CITY OF ALBUQUERQUE

**RE: Mesa Del Sol Self Storage
5500 Turing Dr. SE
Grading and Drainage Plan
Engineer's Stamp Date: 01/15/2025
Hydrology File: R16DA1004**

Based upon the information provided in your submittal received 02/07/2025, the Grading & Drainage Plan is approved for the **Foundation Permit**. The following conditions need to be addressed prior to approval of Building Permit:

CIVIL DETAILS.

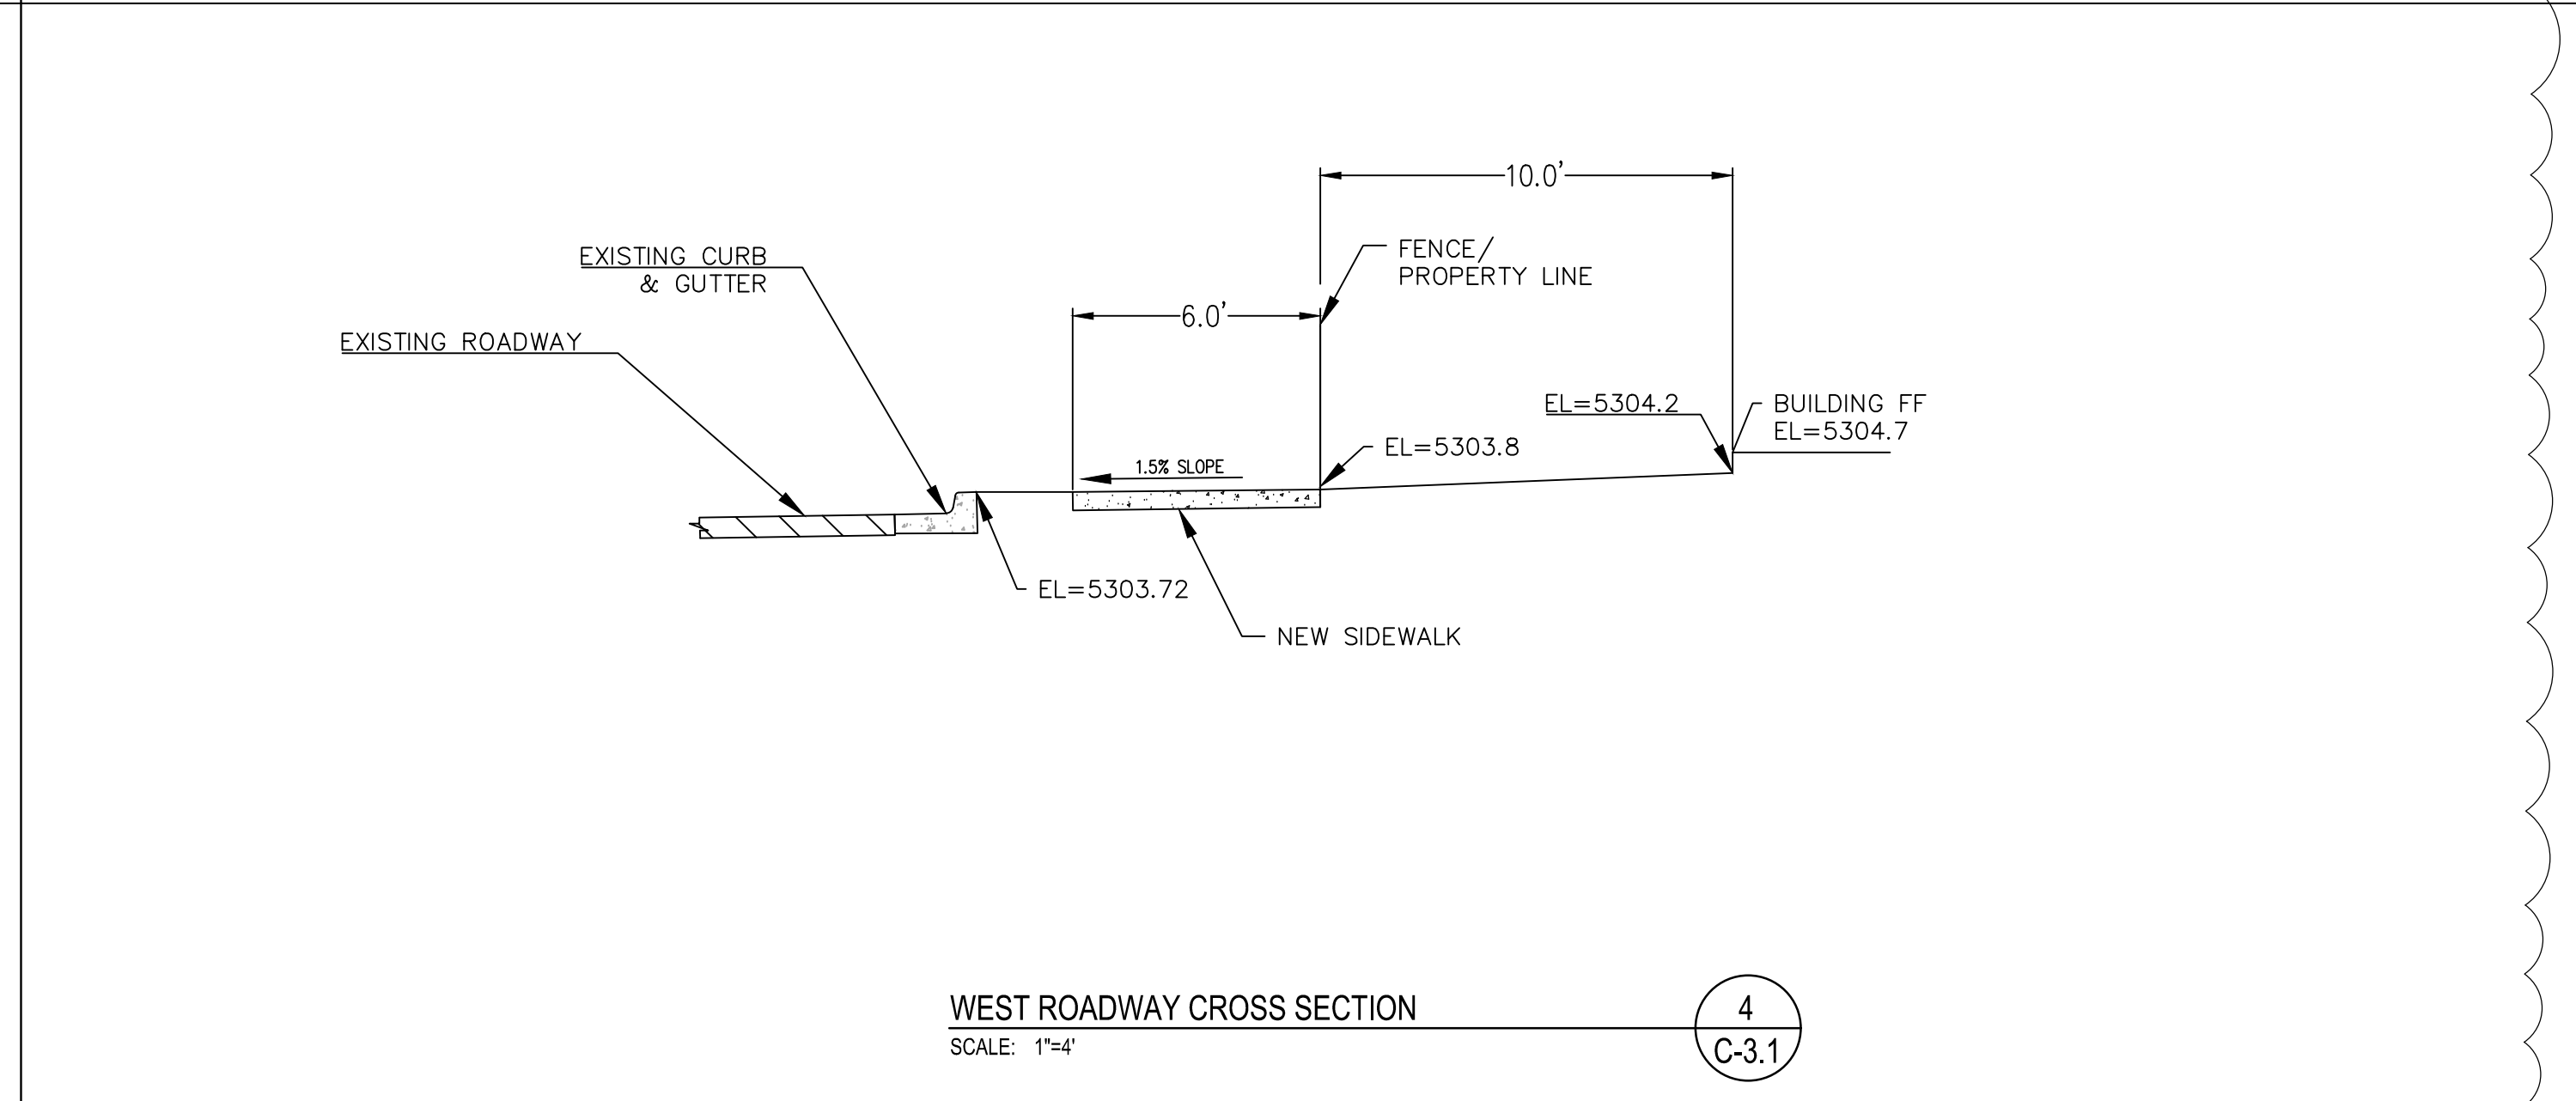
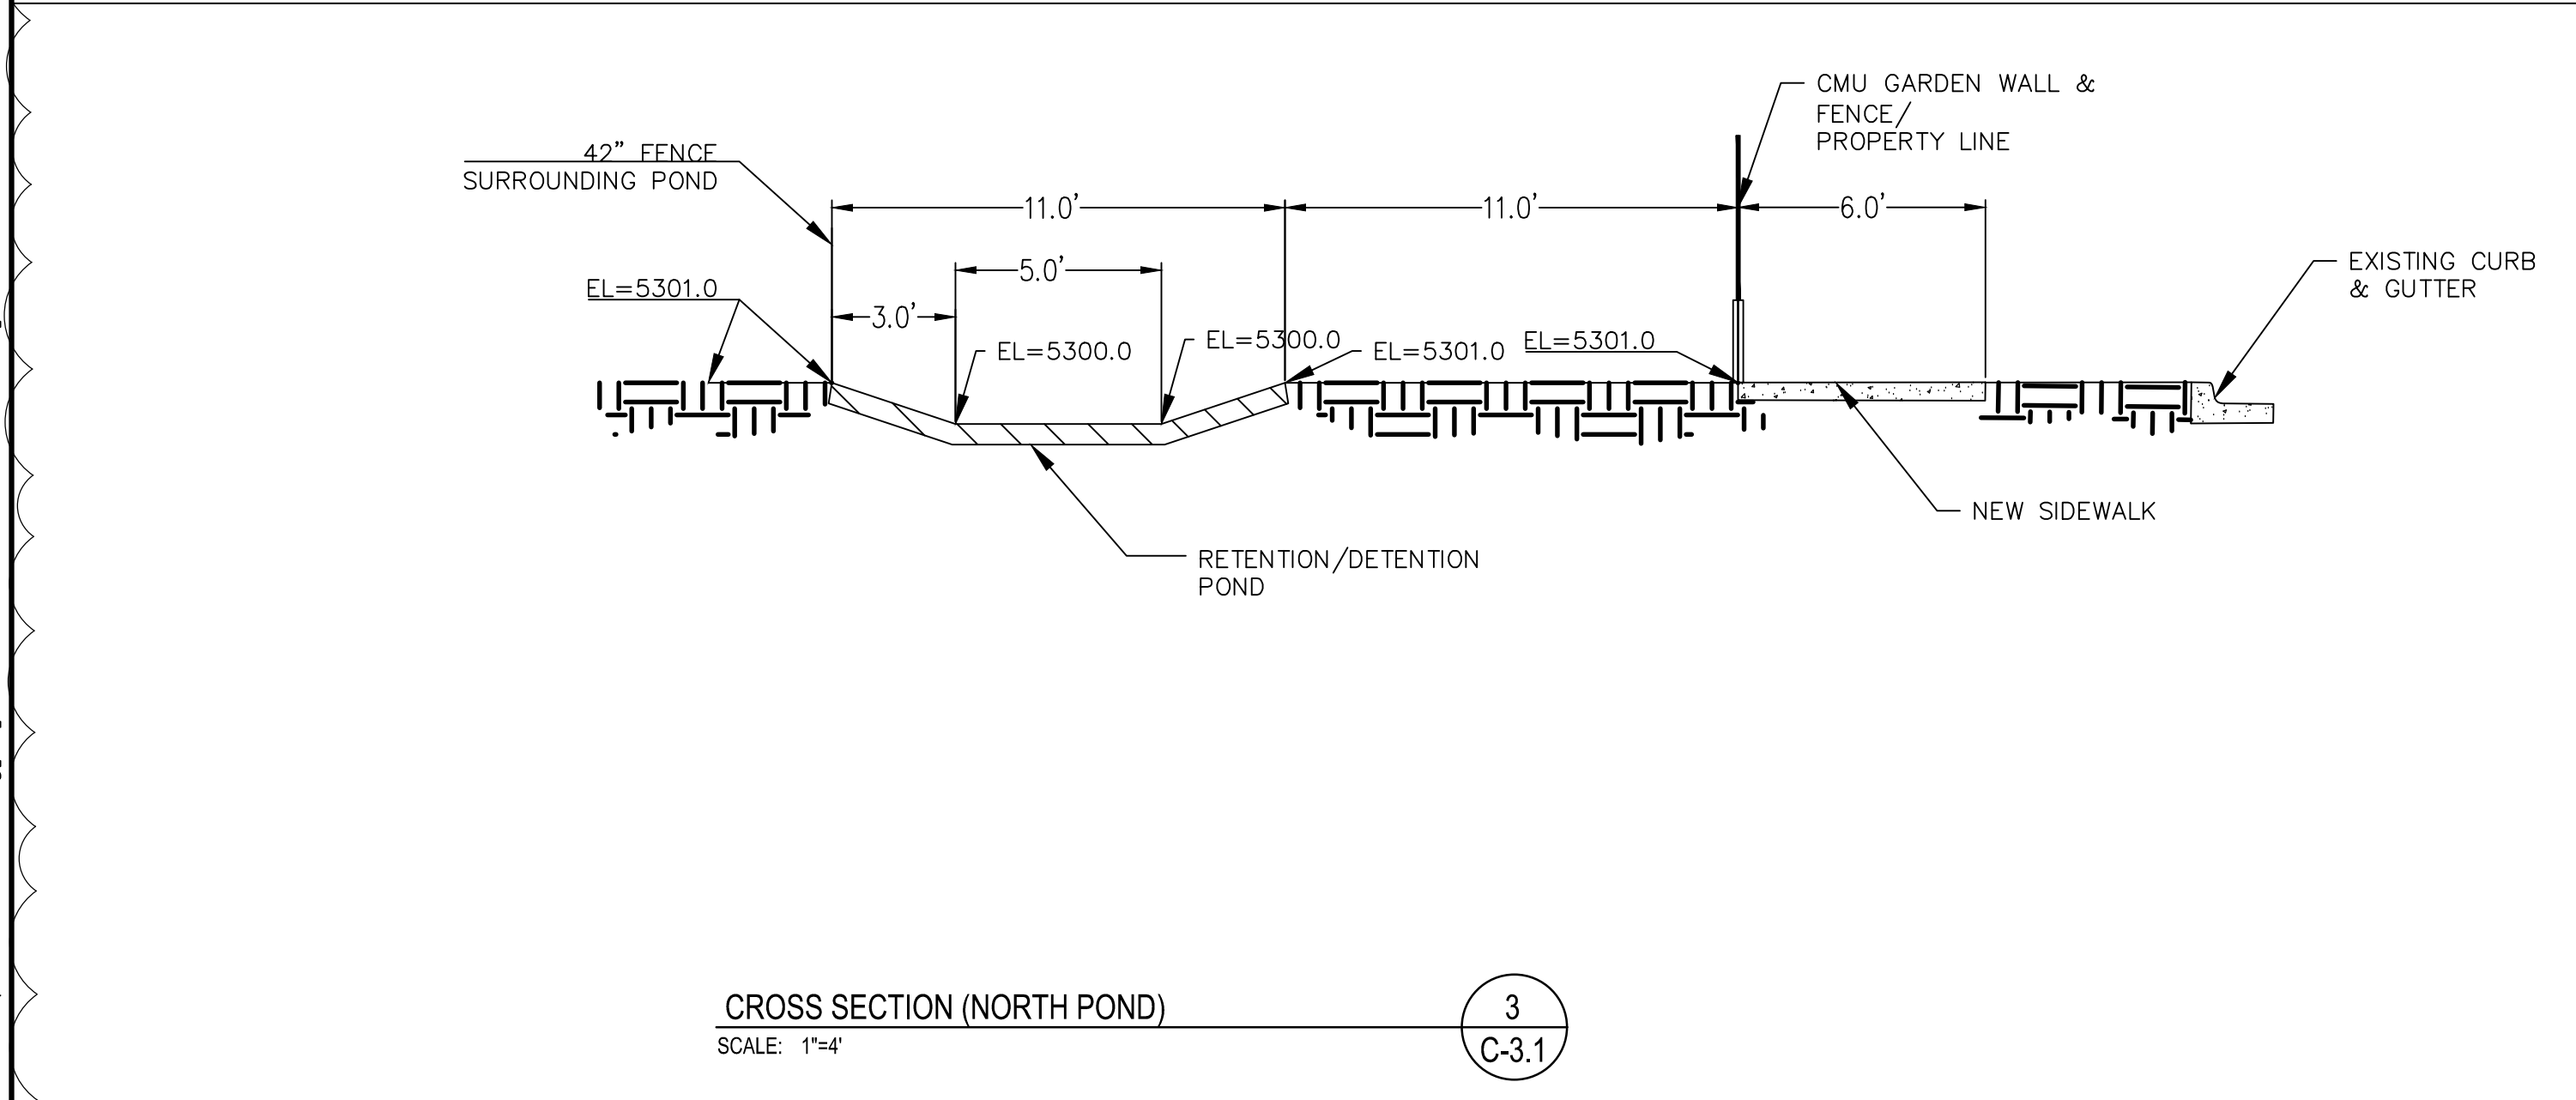
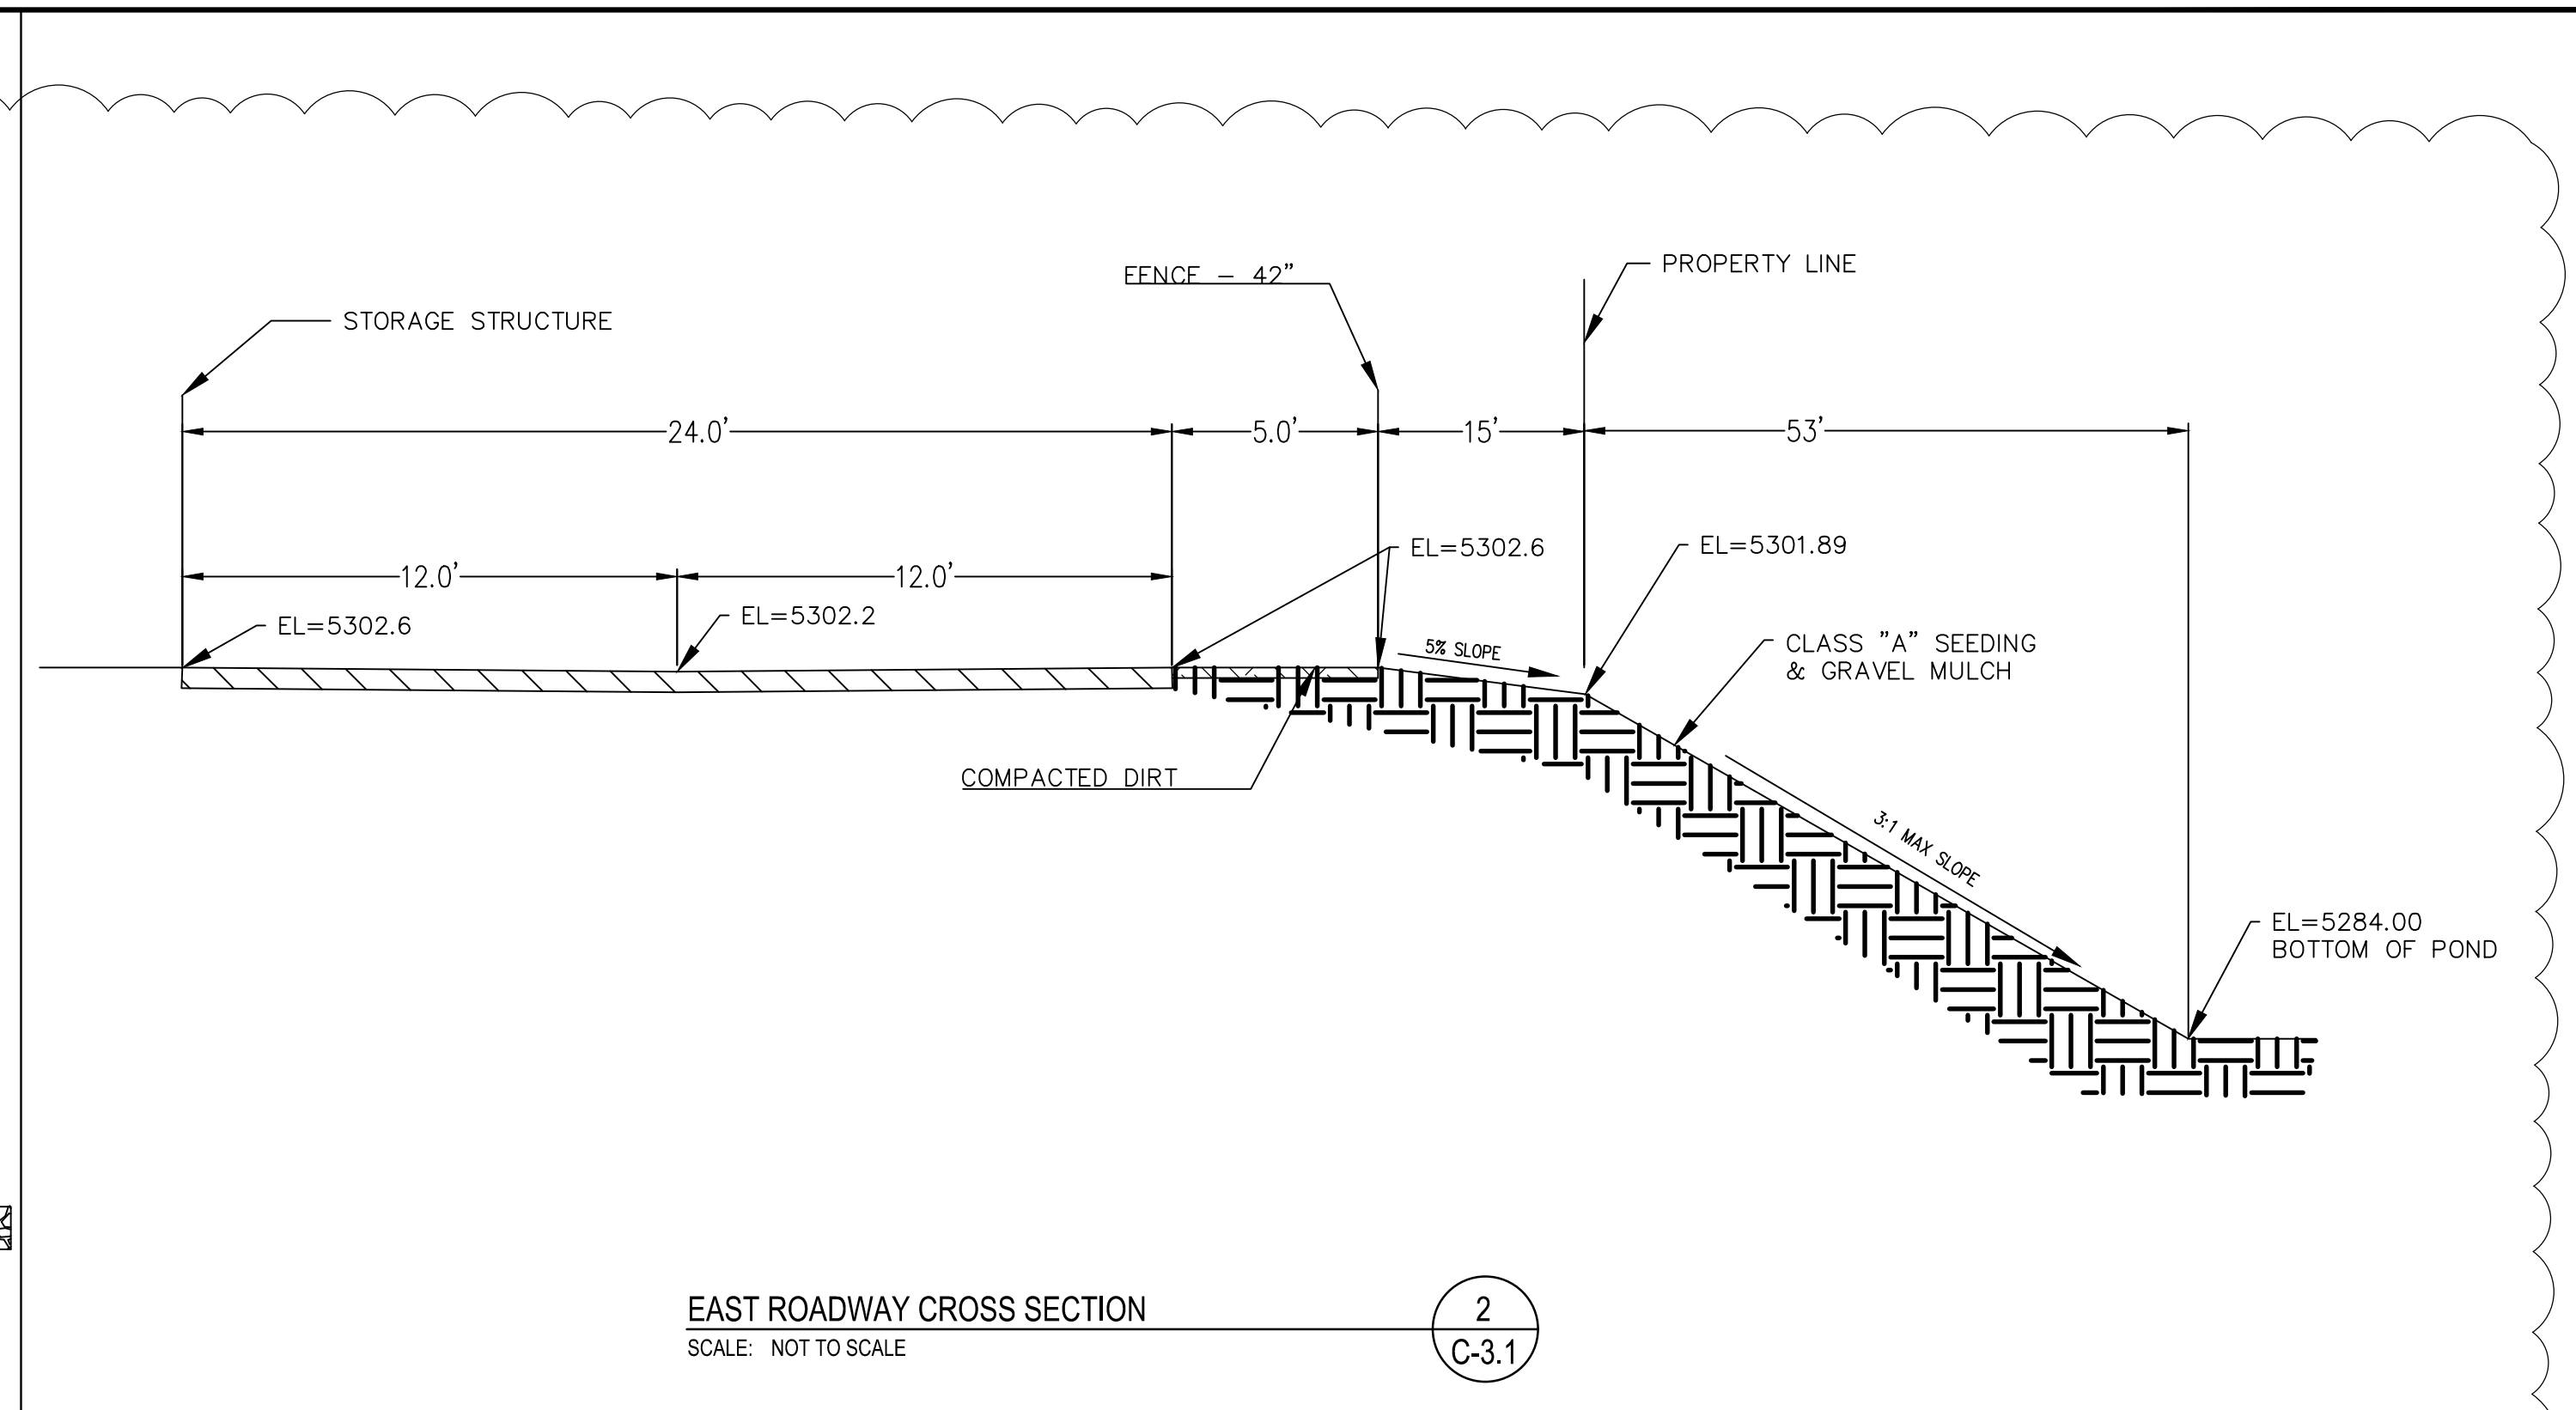
2. Due to the proposed retaining wall in Section 1 of C-3.1, provide an additional cross-section showing the existing storm drain manhole and pipe extension through the proposed retaining wall and into the retention basin at the southeast corner of the project.
